JERRY CLINE PARK TENNIS CENTER  
SUPPLEMENTAL DRAINAGE INFORMATION  
NOVEMBER 11, 2011

RE: Jerry Cline Park (J19/ D26)

I am submitting the revised Grading plan for the proposed tennis clubhouse. Your review comments of September 28 have been addressed as follows:

CITY OF ALBUQUERQUE PARKS & RECREATION DEPARTMENT										
TITLE: CITY OF ALBUQUERQUE JERRY CLINE PARK GRADING PLAN										
Design Review Committee			City Engineer Approval			Last Design Update	Mo./Day/Yr.		Mo./Day/Yr.	
City Project No.		Zone Map No.								
677402		J-19

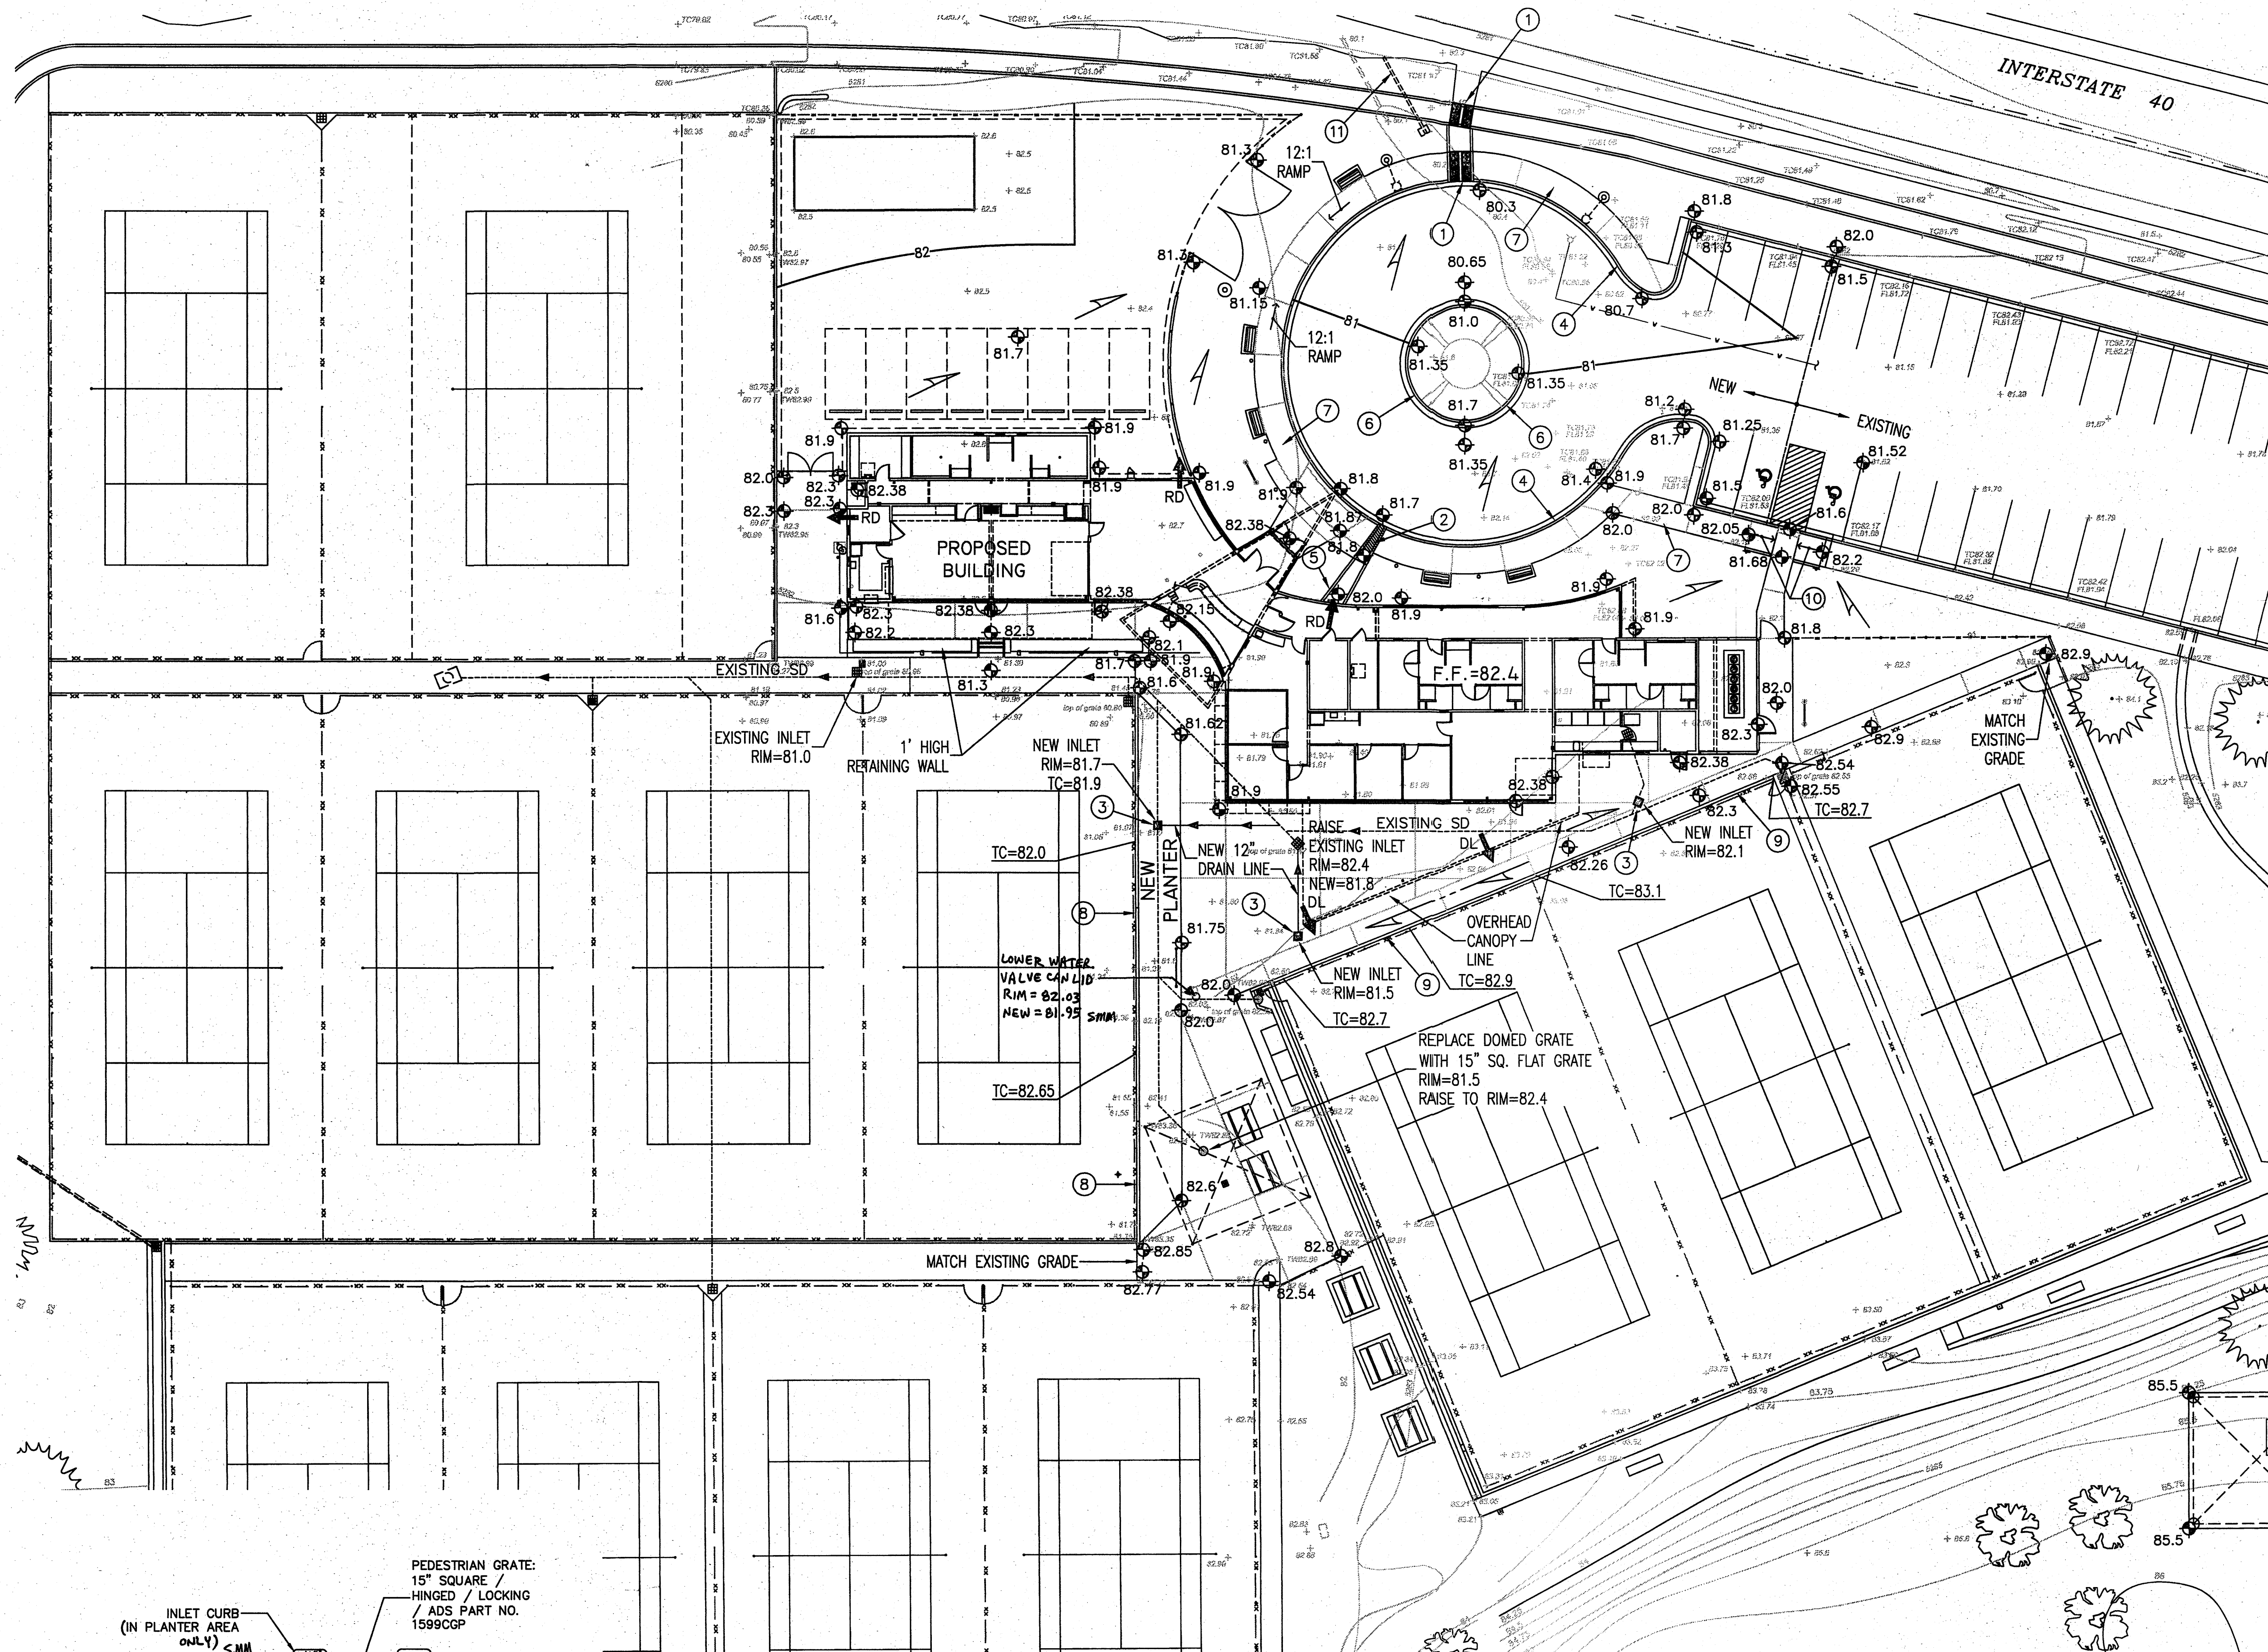
- < The NAVD 88 requirement was waived by Curtis Cherne for this ongoing City project.
- < Existing contour labels and spot elevations are now more bold.
- < No work is proposed within the NMDOT R/W. Site discharge enters an existing City storm drain system onsite.
- < The property line has been noted.
- < The existing drainage swale was previously cobble lined.
- < Calculations have been added to the Supplemental Drainage Information. A detail has been added for the U-shaped concrete channel.
- < Existing inlets under the proposed inlet will be relocated. The Architect's Demolition sheet addresses a portion of this work.
- < A single finish floor elevation is proposed for this single odd-shaped building.
